# YARNTON PARISH COUNCIL

20th November 2024

**Re: Application No: 23/02098/OUT - Oxford University Development (OUD) Consultation**

Figure 5.1: Maximum modelled depth in the 3.33% AEP event, 11 hour storm duration

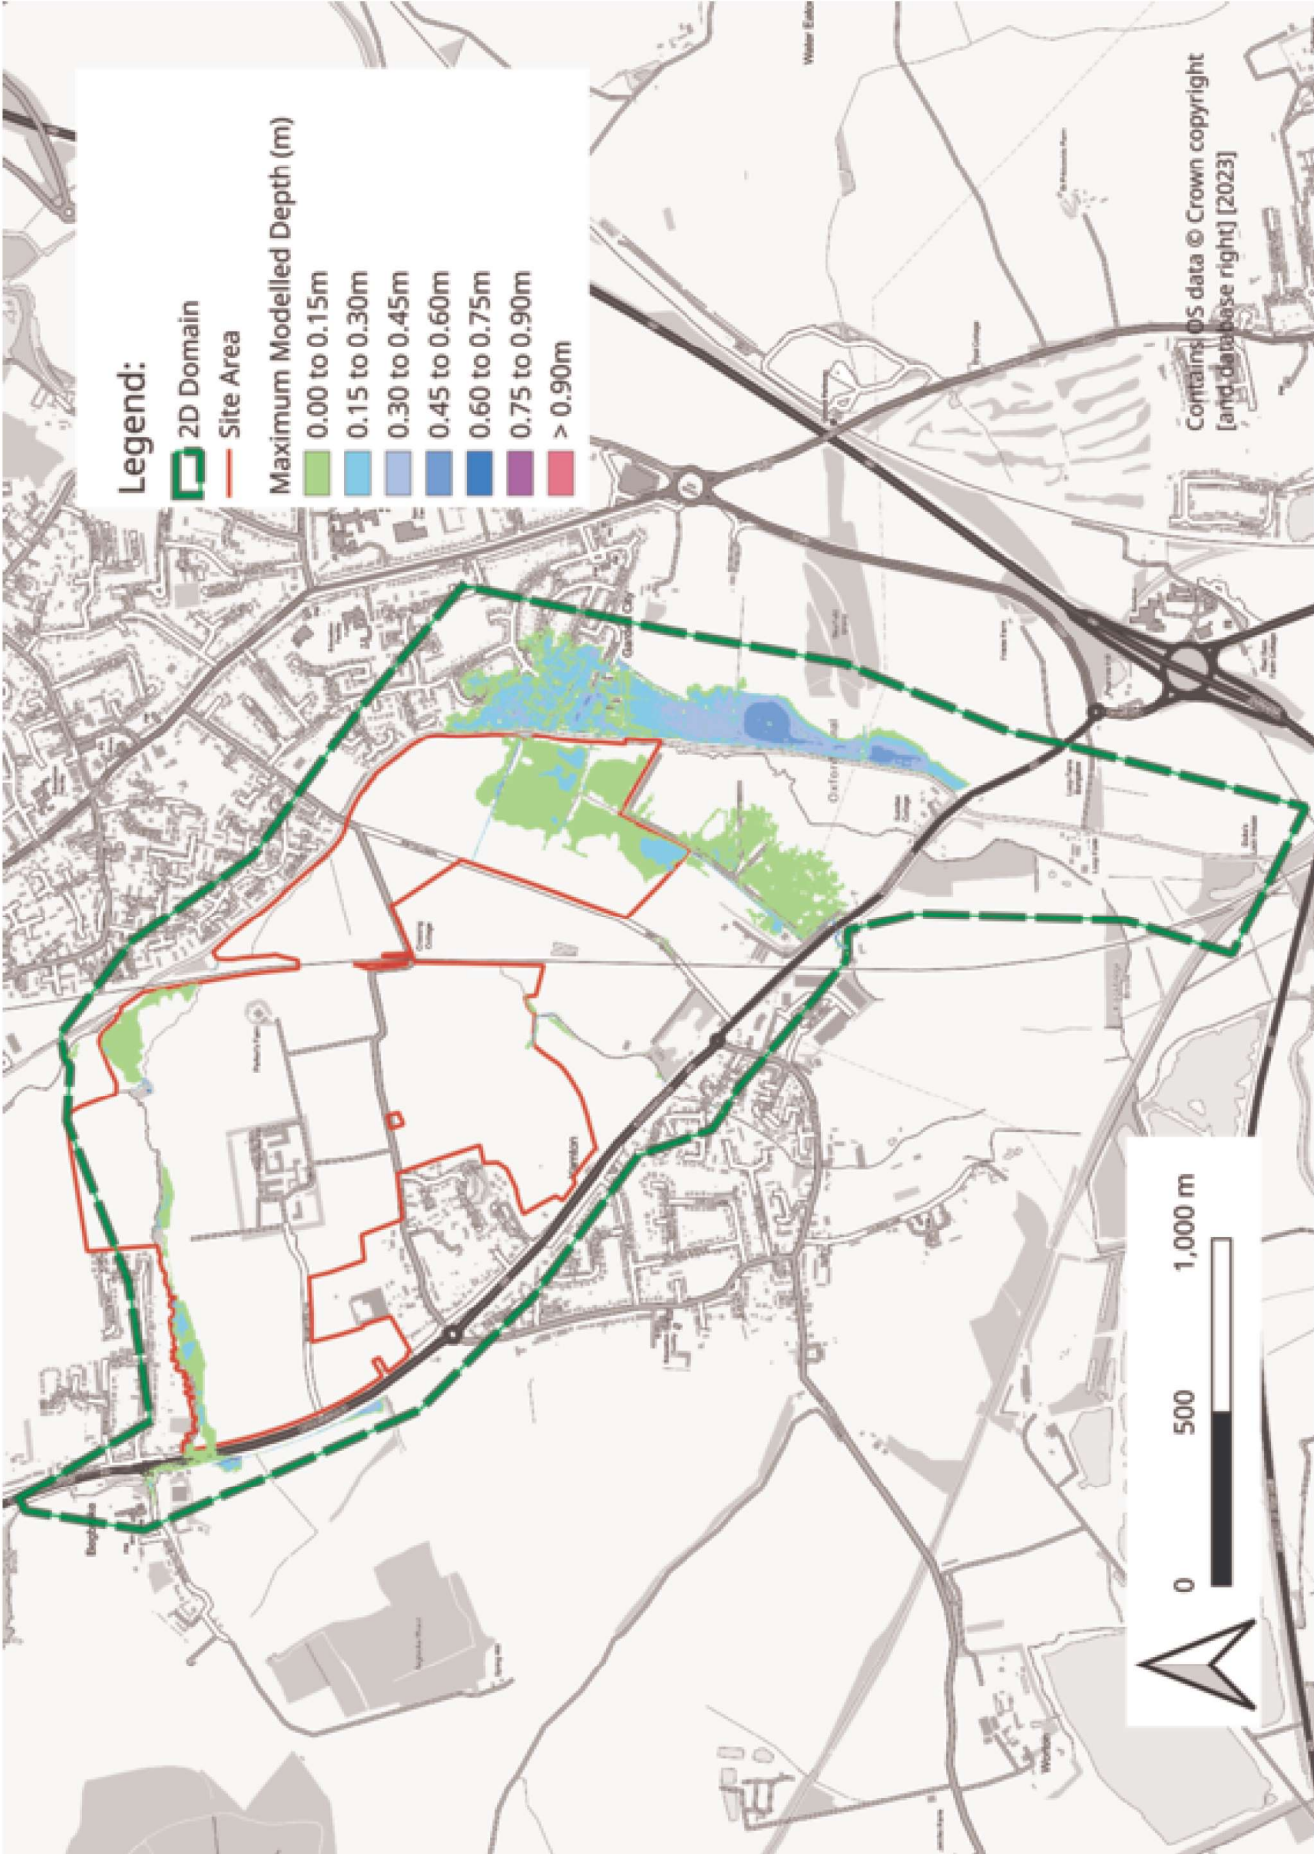
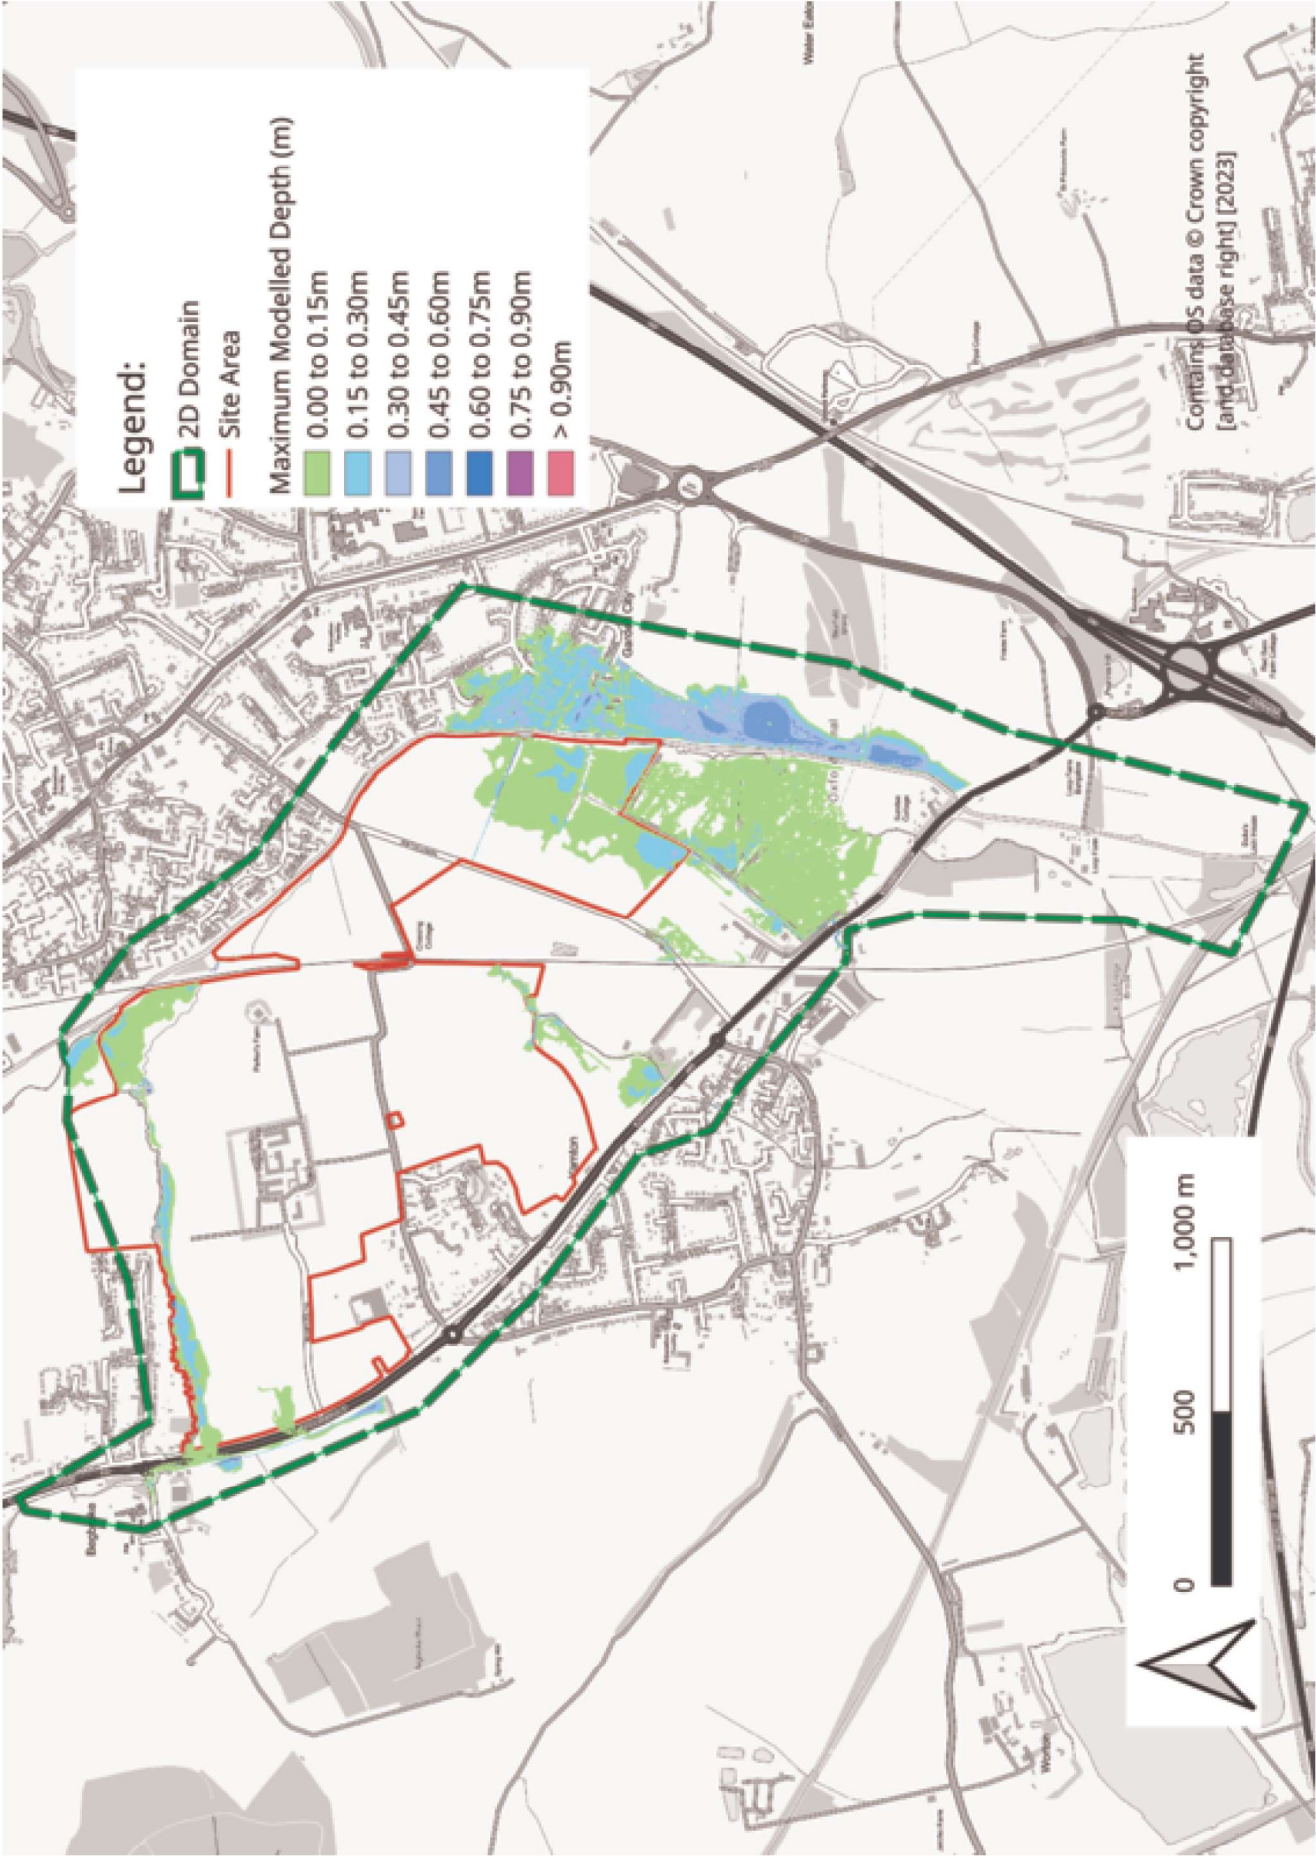
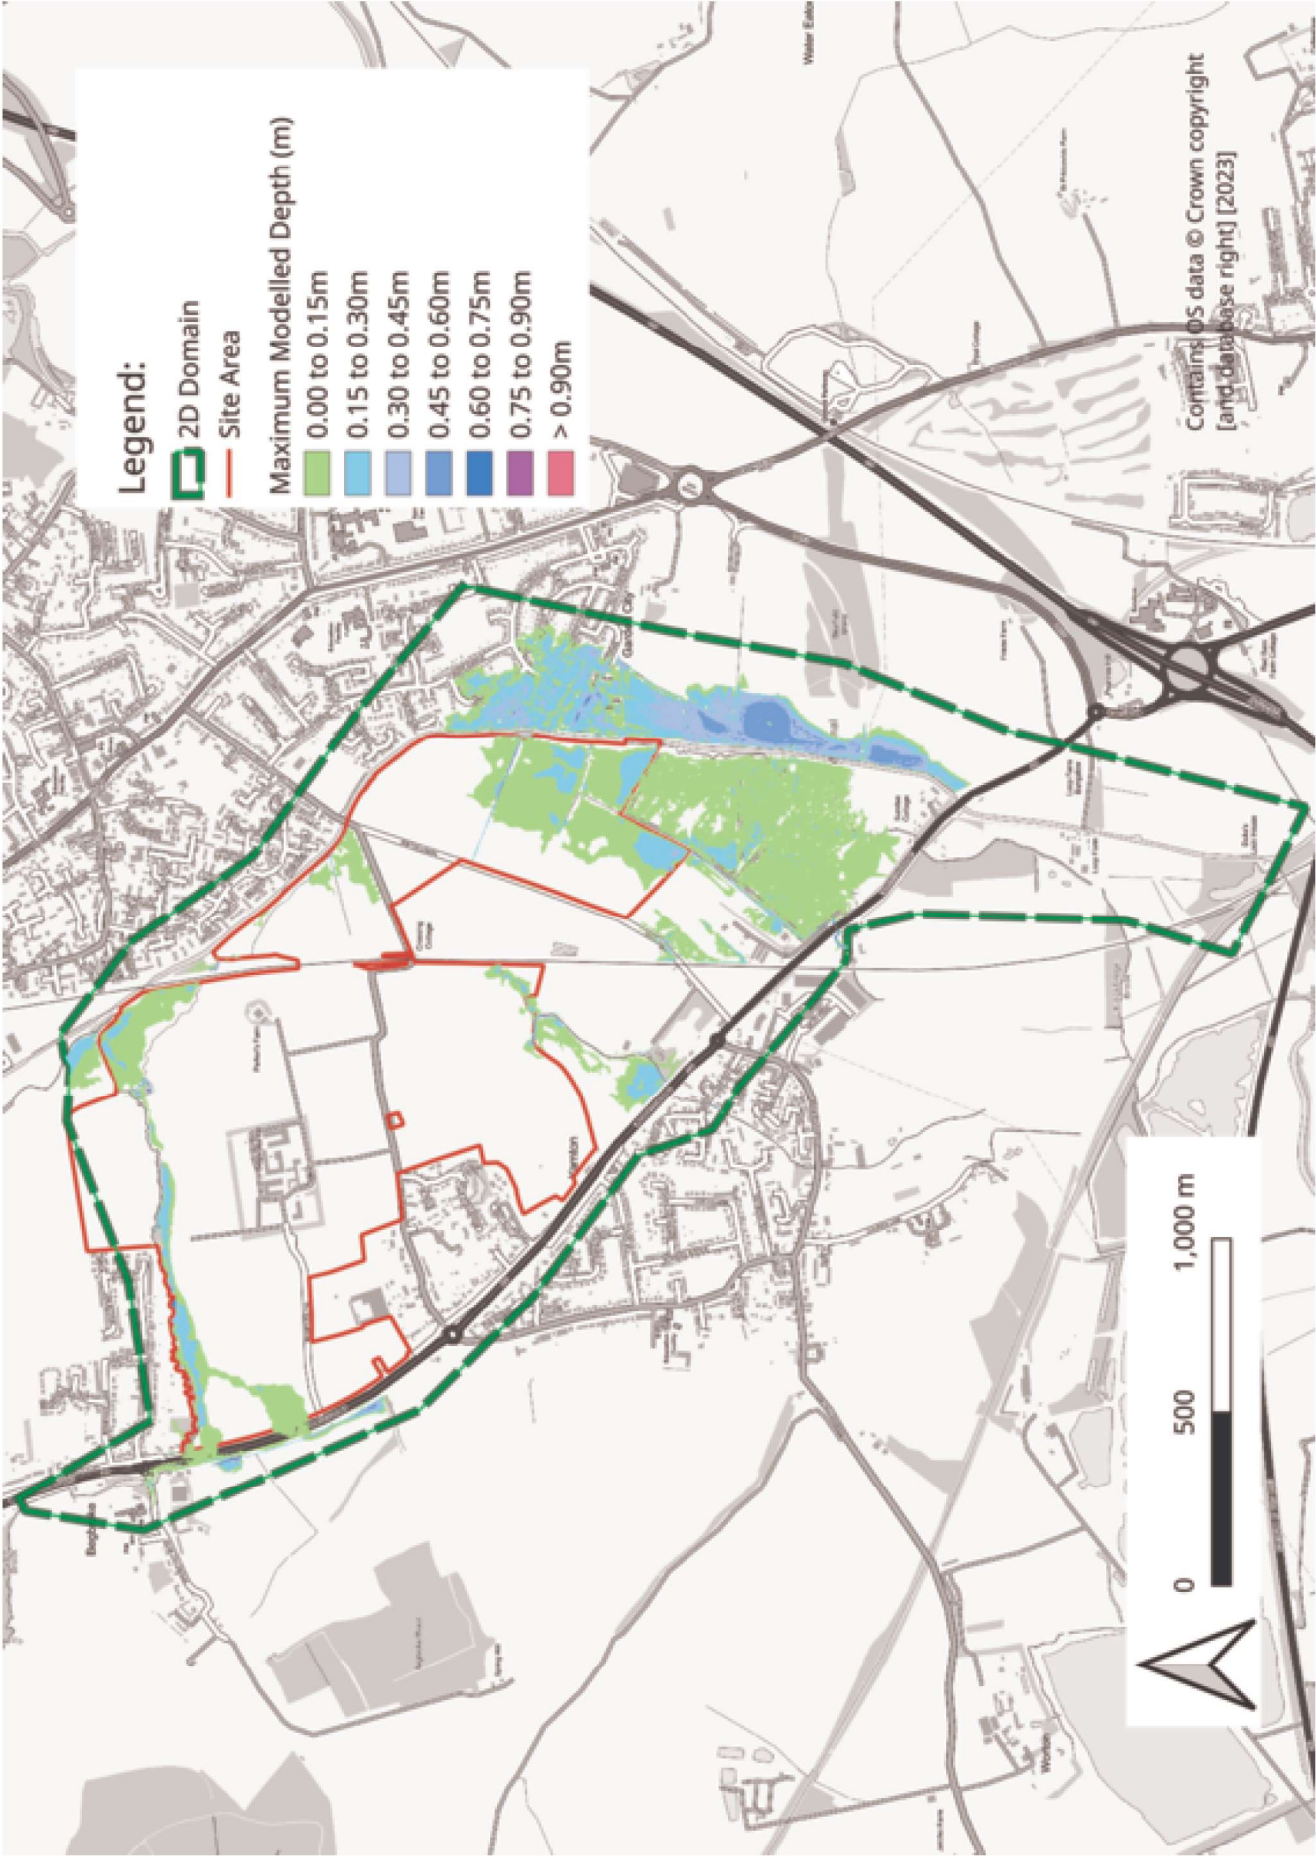
18. The Edenvale report includes a number of flood output maps [Figures 5.1~5.5] which seems to show flooding below a 1 in 100 year return period as very limited. As we said earlier this does not accord with our observations over the last 20 years. Until they have produced a baseline model which is more closely aligned with empirical observations, we do don't consider they are able to produce a design which will deliver the 1 In 100 return period risk which is required.

19. An interesting feature of the flood output maps [Figures 5.1~5.5] is they consistently show a large area of flooding east of the canal; the Stratfield Break and Garden City areas in Kidlington. Those areas rely upon a 200 year old inverted siphon in an unknown condition for drainage and feeding into the Yarnton catchment.
